EL PASO COUNTY PARKS DEPARTMENT | PARK PLANNING DIVISION

March 24, 2026

Subject: The Markets at Bent Grass -Preliminary Plan (SP-26-002)

PRELIMINARY GRADING PLAN

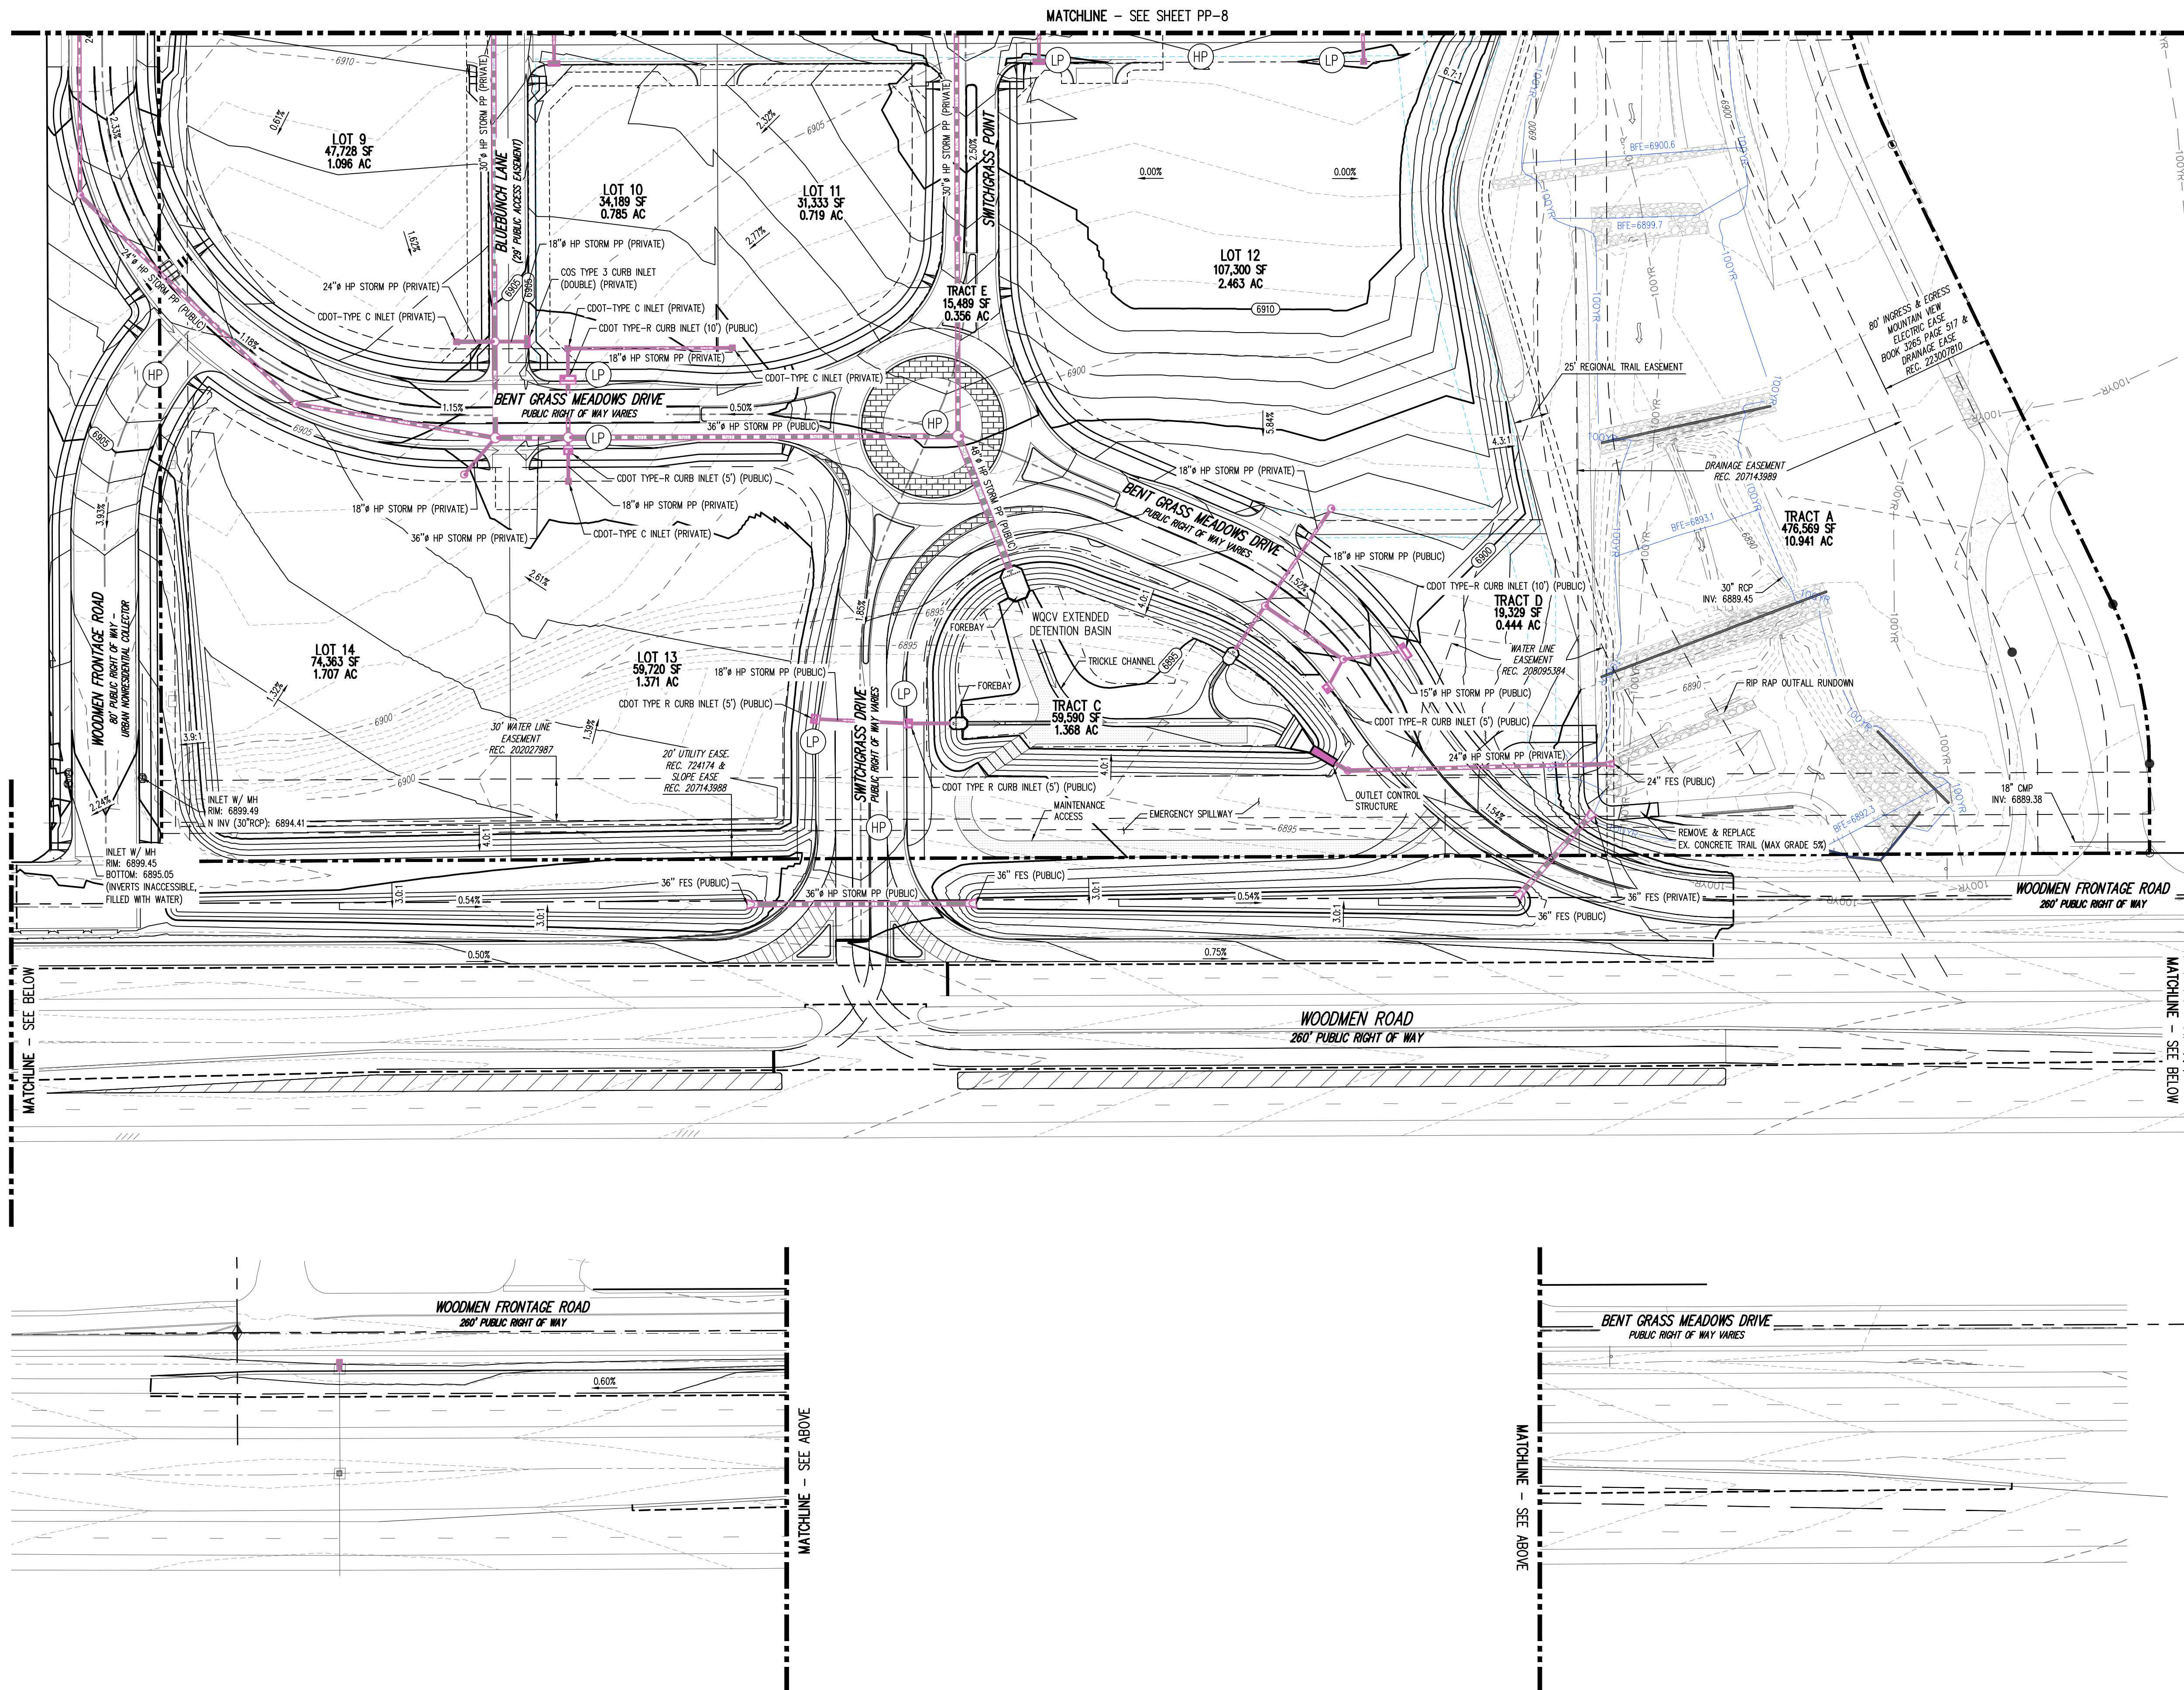
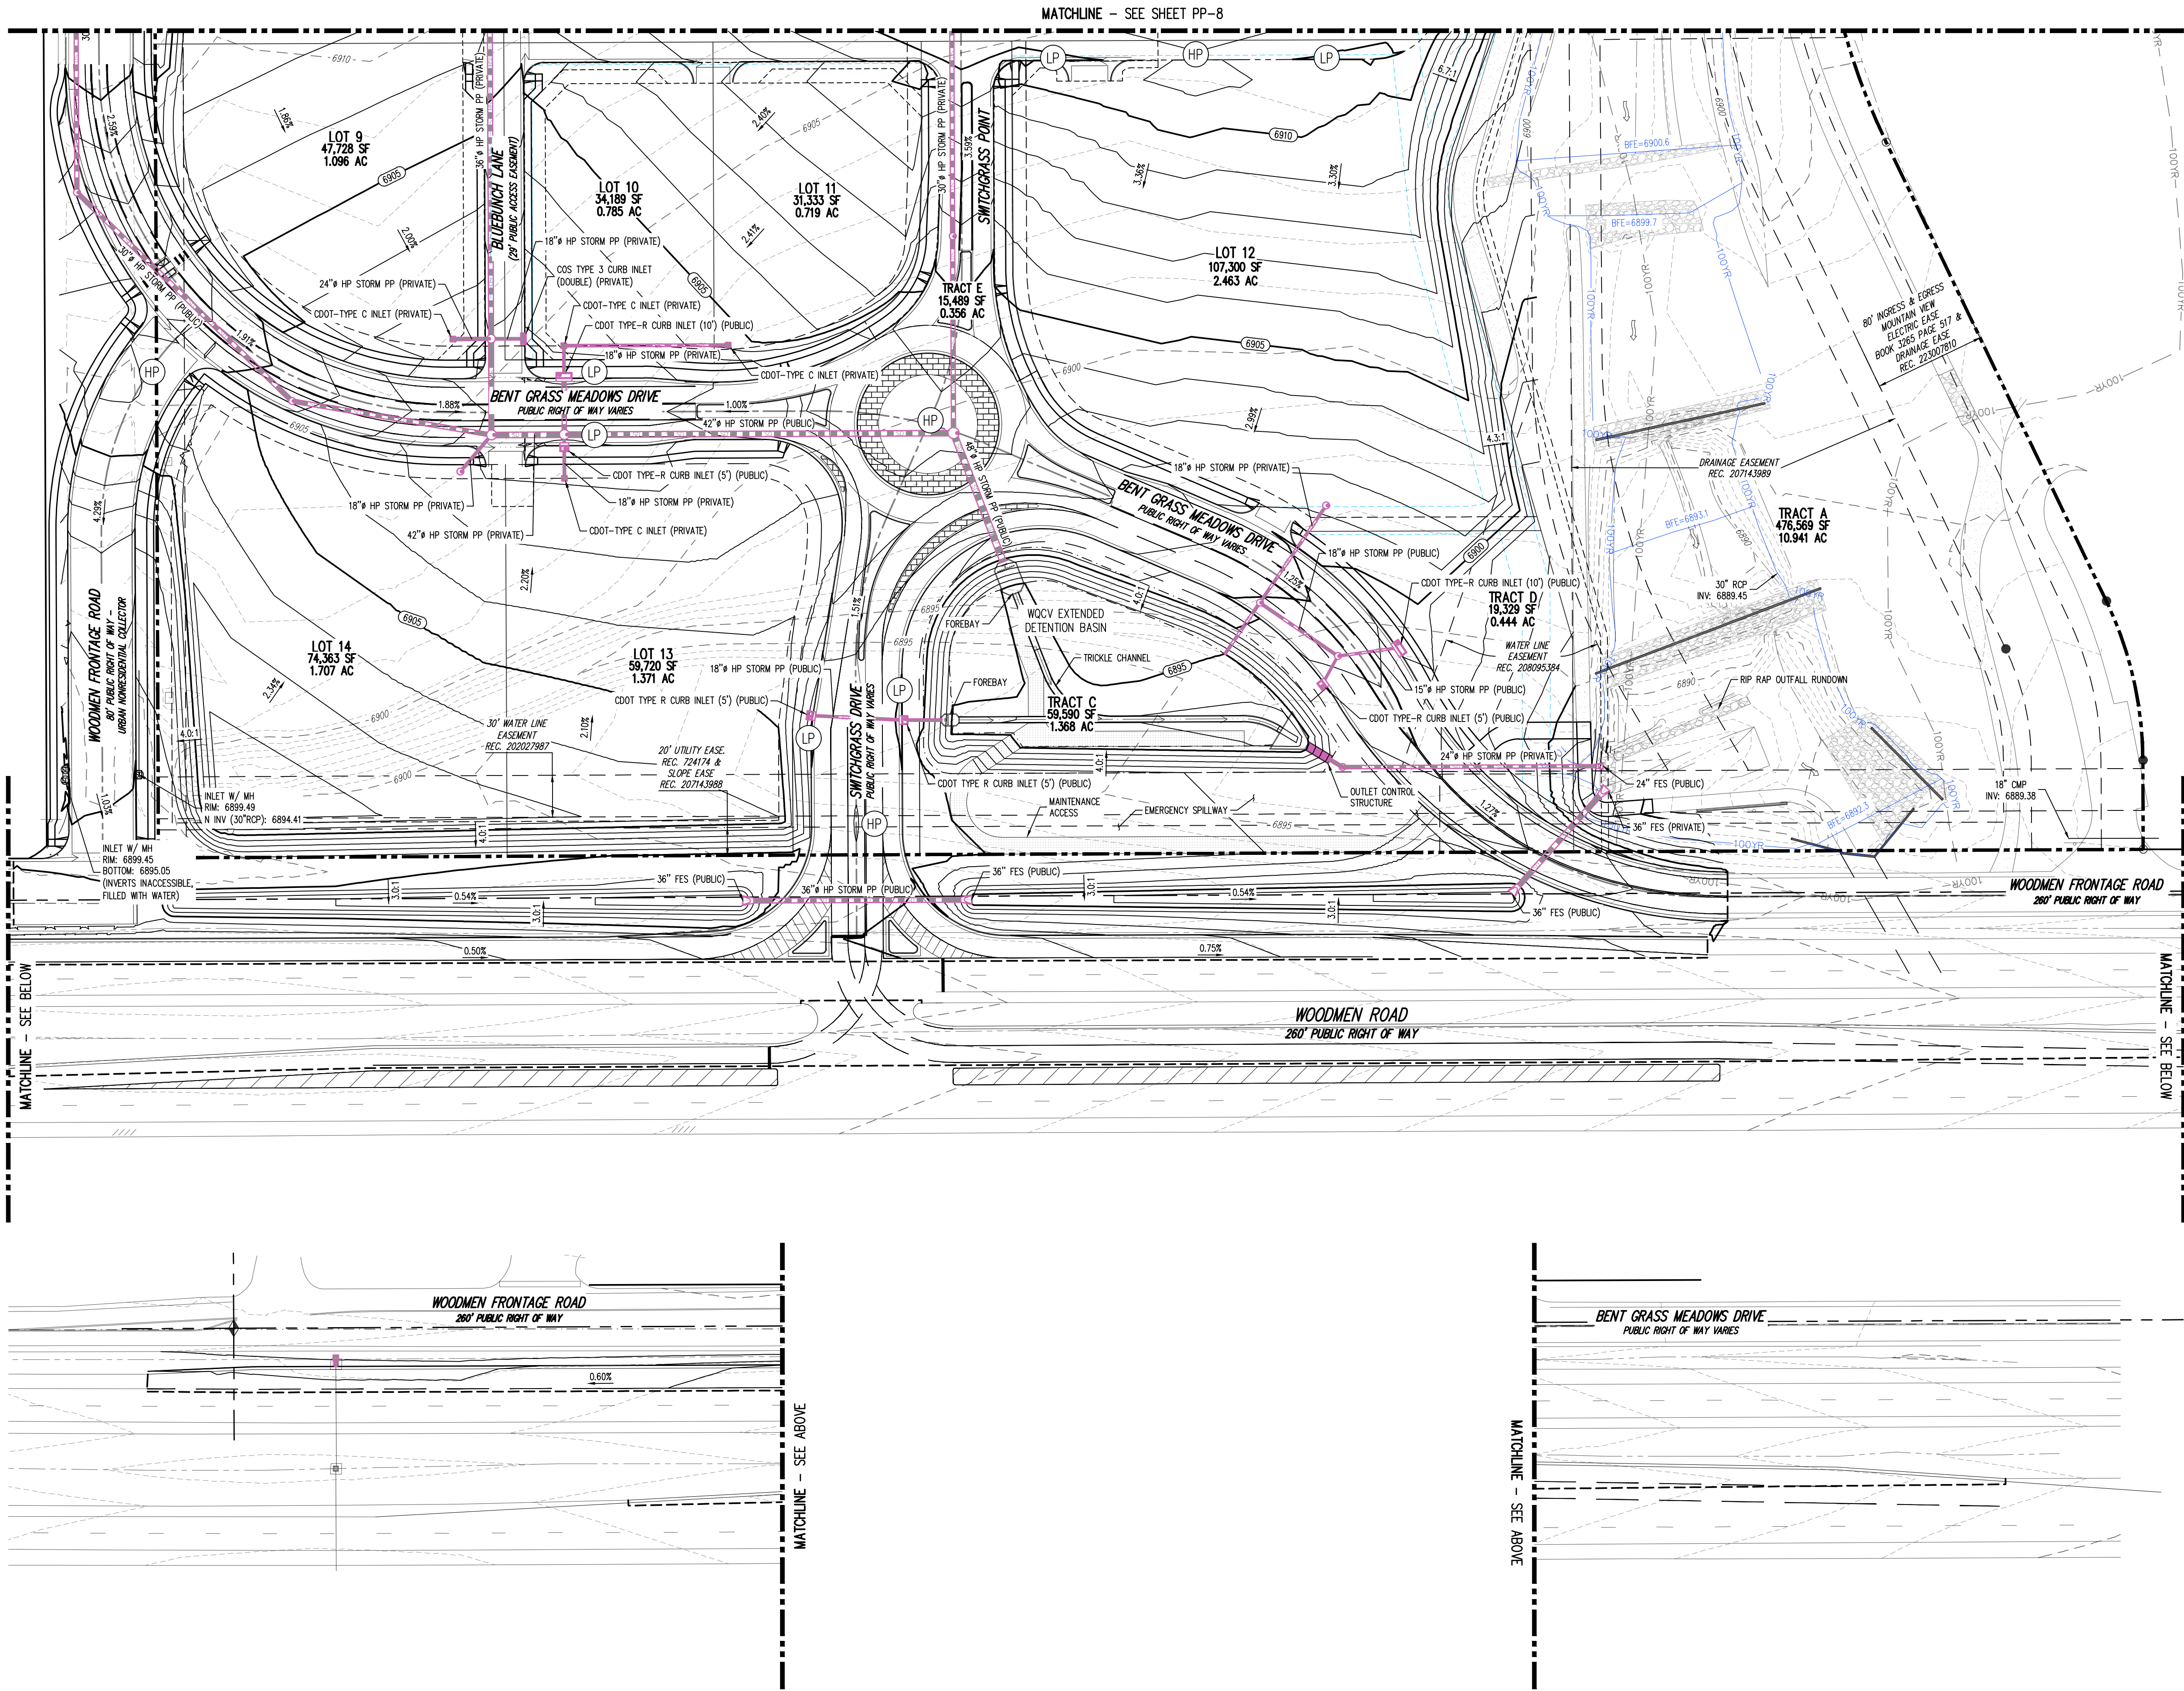
As previously mentioned, a portion of the Woodmen Hills Secondary Regional Trail exists along the Easterly drainage corridor that both connects to Woodmen Road and traverses underneath via a concrete box culvert. After reviewing the preliminary plan and associated grading plans, it's unclear how the proposed trail will connect to the existing trail. Staff requests the applicant update the grading plans to demonstrate how the proposed trail will connect to the existing trail at Woodmen Road and underpass.

PP-3
3 OF 12

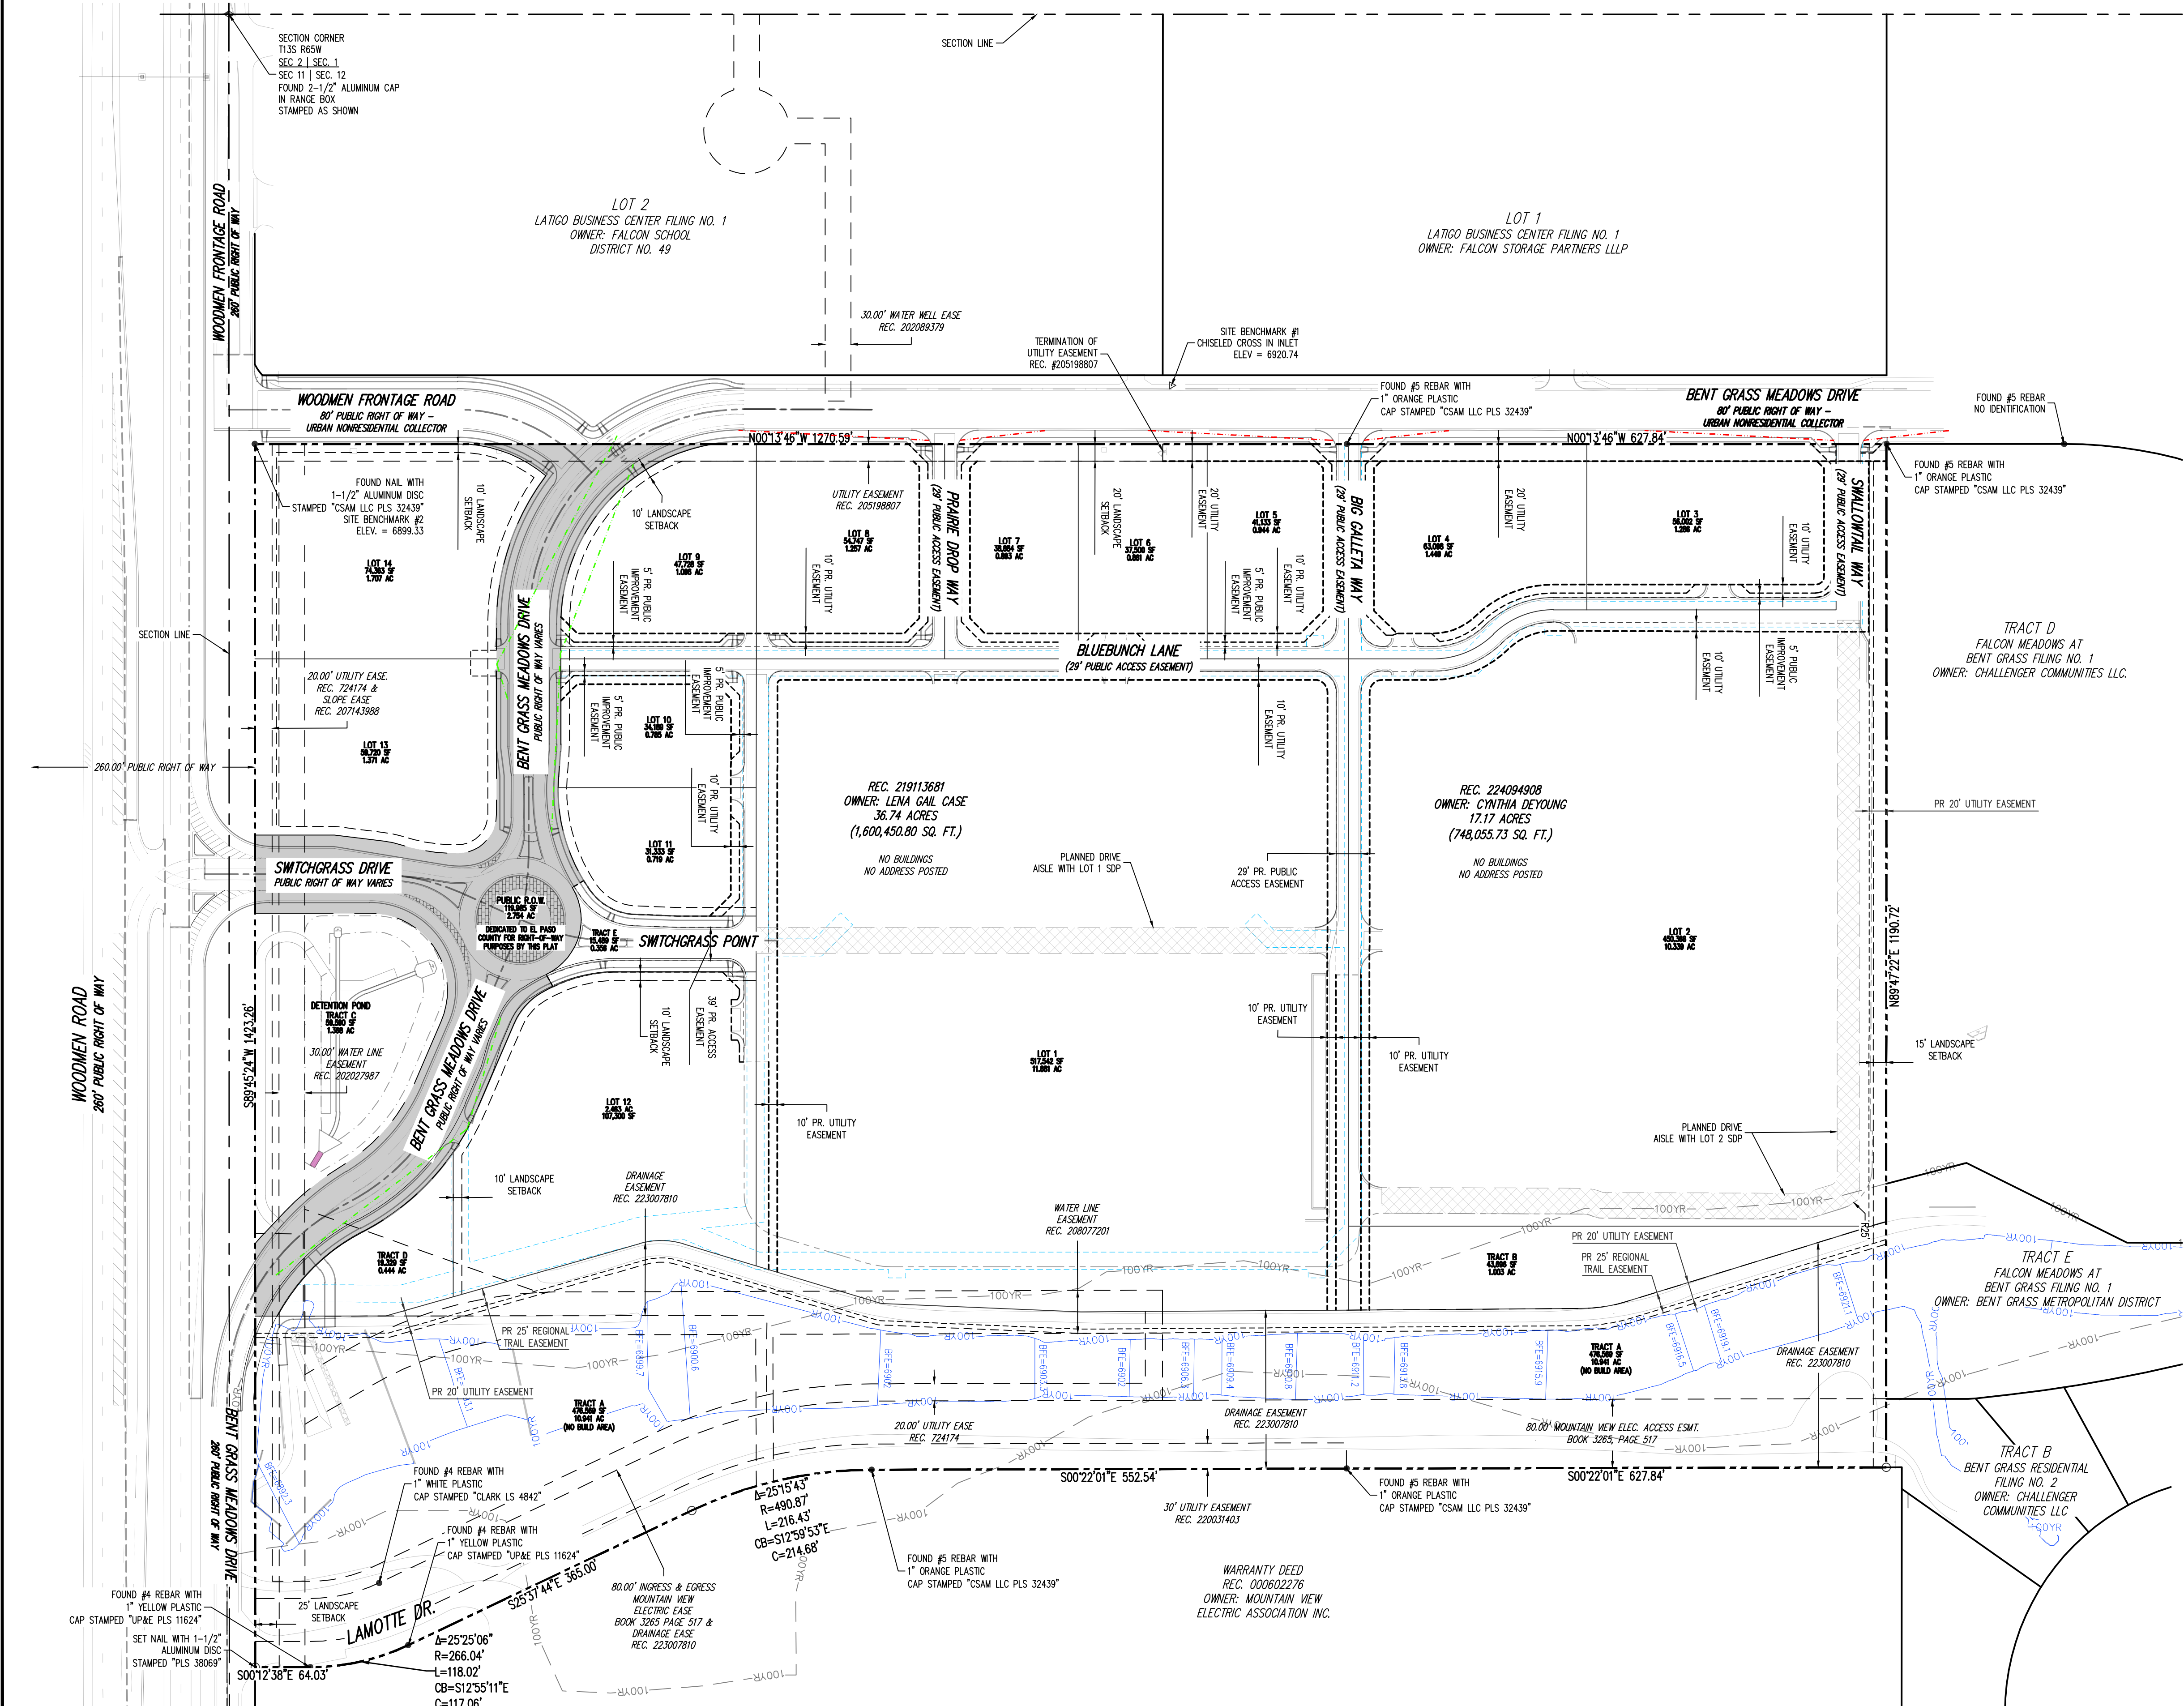
The preliminary plan currently depicts a 25' trail easement along the easterly drainage consistent with the El Paso County Parks Master Plan on page PP-3 Lot & Tract Plan. However, staff requests that a note identifying the trail easement to El Paso County be included at both the preliminary plan and final plat stages.
